Application Reference: 2026/0366

Site Address: 40 Green Spring Avenue, Birdwell, Barnsley, S70 5RY

Proposal: Demolition of existing garage and erection of replacement outbuilding.

Drawing Title:
**PLANS, ELEVATIONS
 & SITE PLANS
 AS PROPOSED**

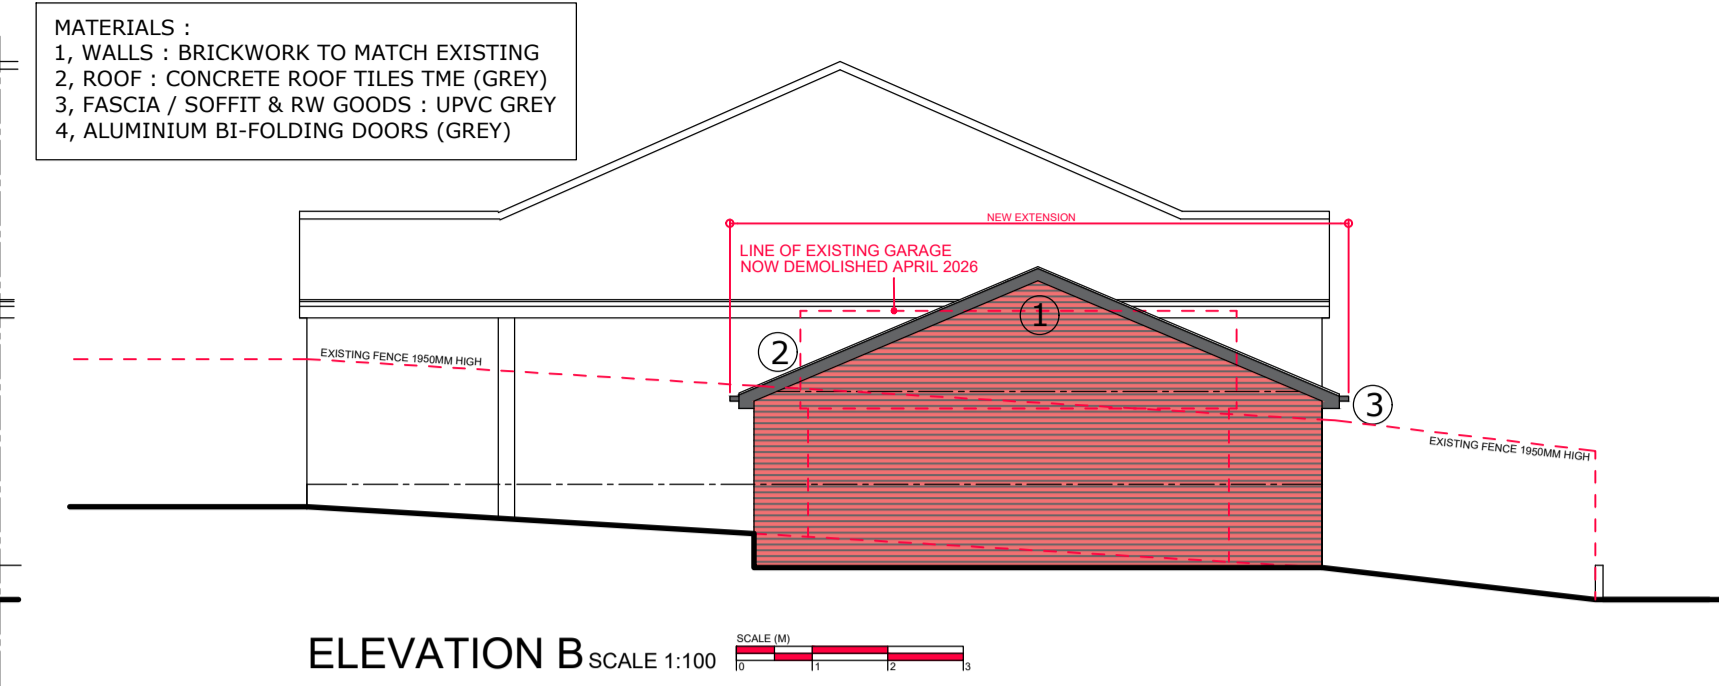
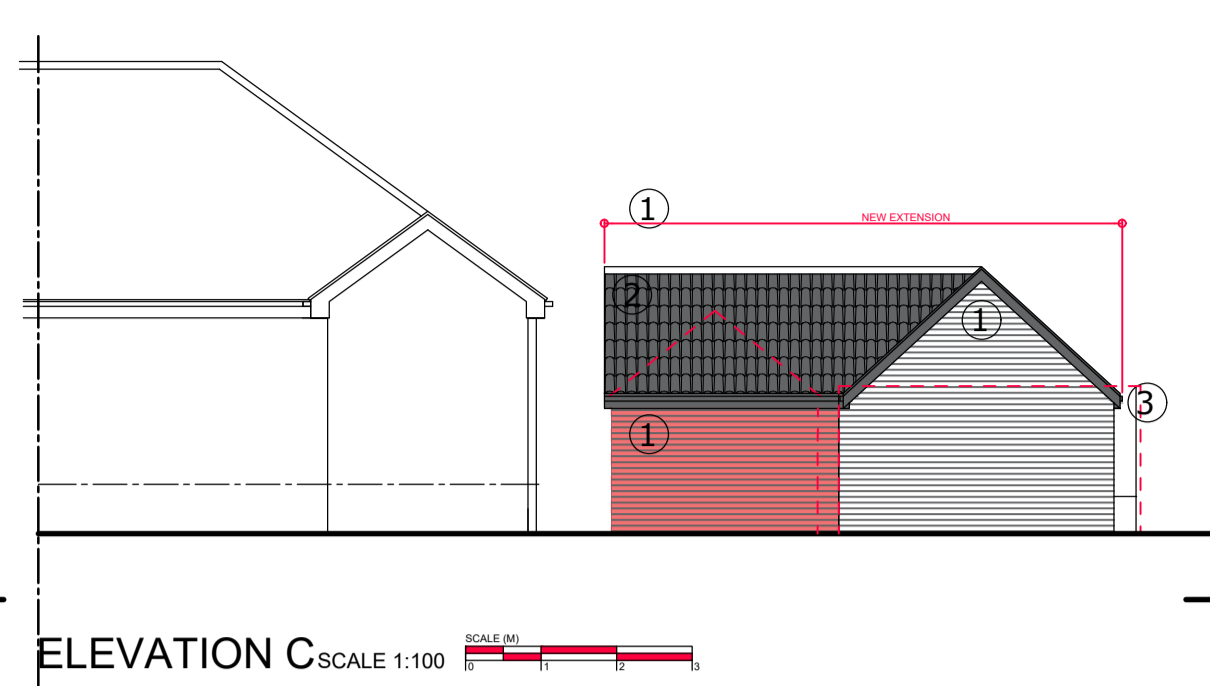
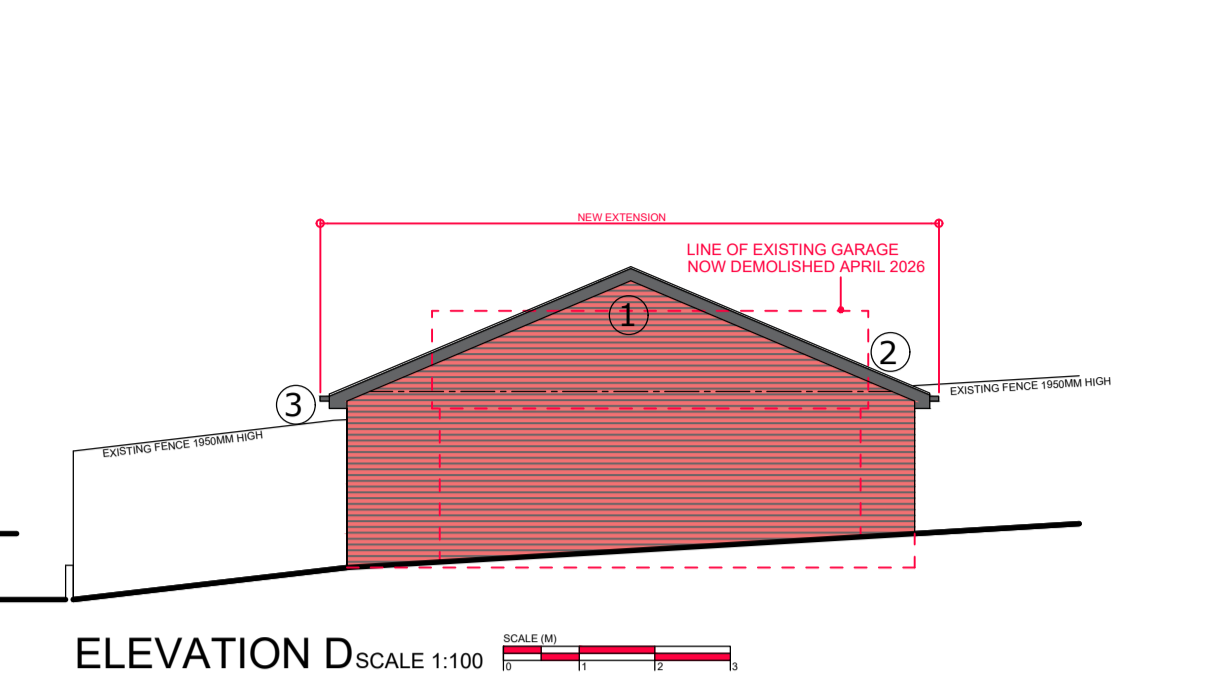
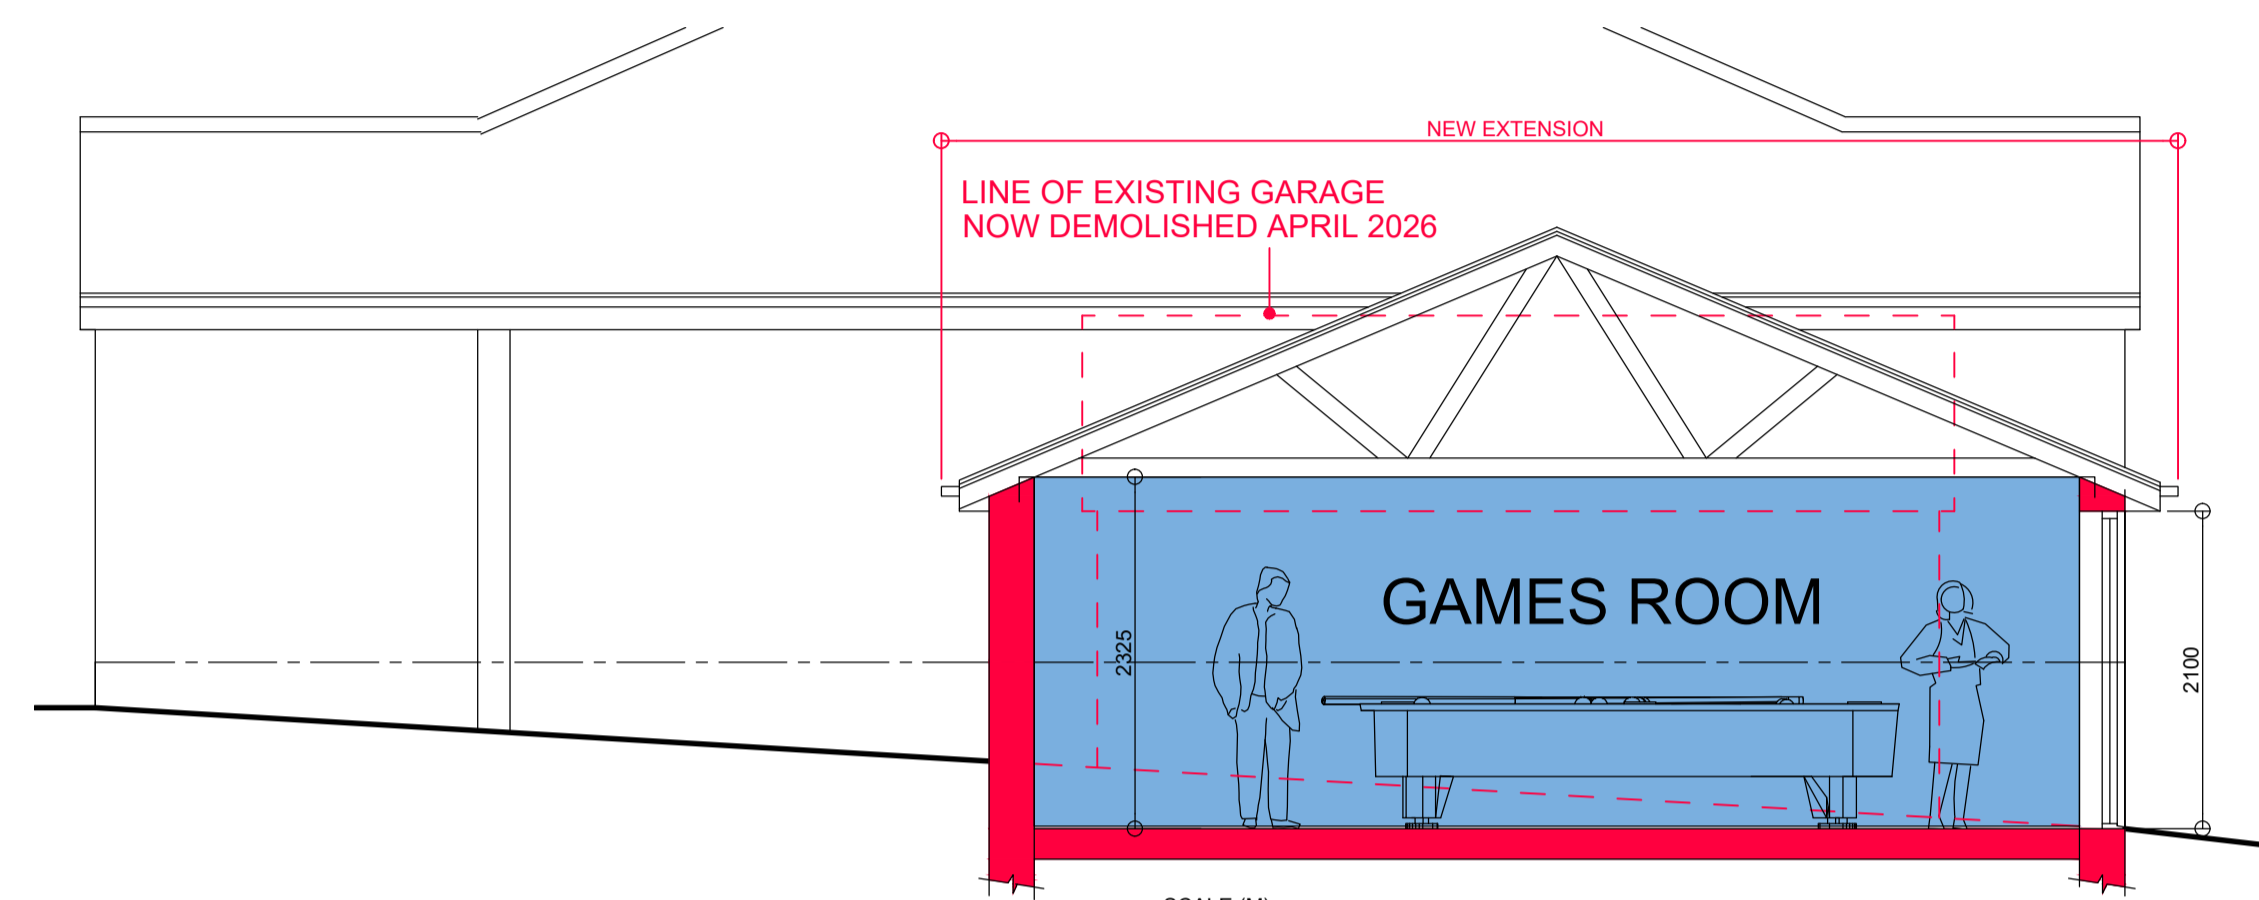
- Will the proposed outbuilding will be used for domestic enjoyment and not commercial activities?
- No physical dimensions of the proposed height have been outlined on the proposed elevations.

Neighbouring comments highlighted the eaves and ridge height were not detailed on the elevations. An acceptable scale was provided which allowed the eaves and ridge height to be measured from, providing an eaves height of 2.1 metres and a ridge height of 3.9 metres.

The proposal provides a modest floorspace at approximately 28 square metres, significantly less than the 39 square metres generally considered acceptable for outbuildings. The proposal details a pitched roof, which would be in keeping with the character of the dwelling and street scene. When measured, the proposal provides a modest 2.1 metre eaves height and a modest 3.9 metre ridge height which are considered acceptable against the House Extensions SPD.

SITE PLAN AS PROPOSED SCALE 1:100

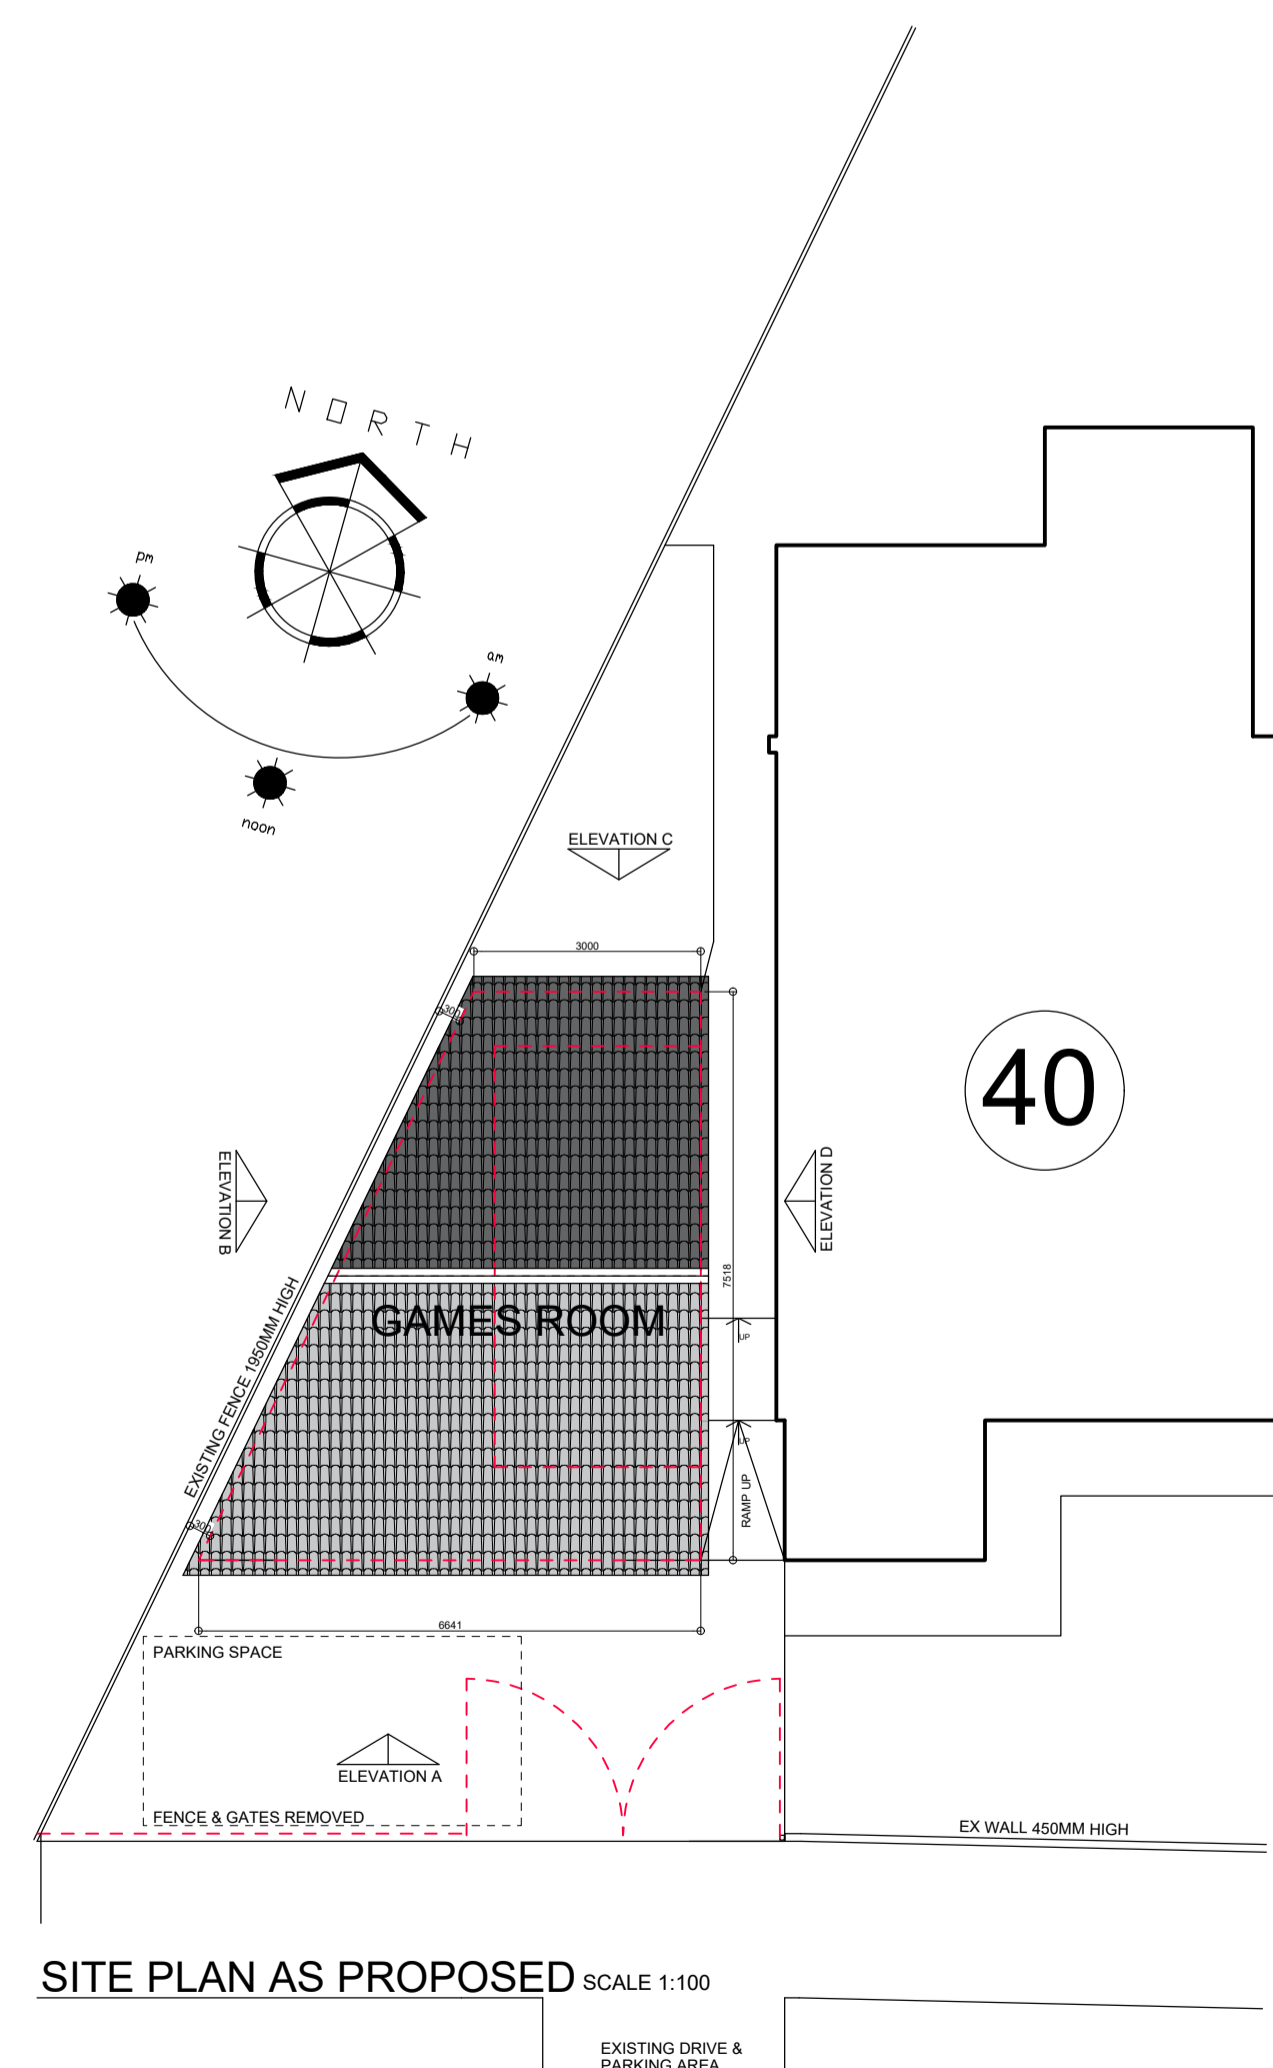
The proposal would not increase the number of bedrooms on site. The proposal would result in the loss of 1 parking space from the existing garage. A parking space has been detailed to be retained to the front of the outbuilding and parking is available to the front of the dwelling in a similar fashion to neighbouring dwellings.

As such the proposal is considered acceptable in terms of its impact on highway safety and in compliance with Local Plan Policy T4 New Development and Transport Safety. This carries significant weight in favour of the application.
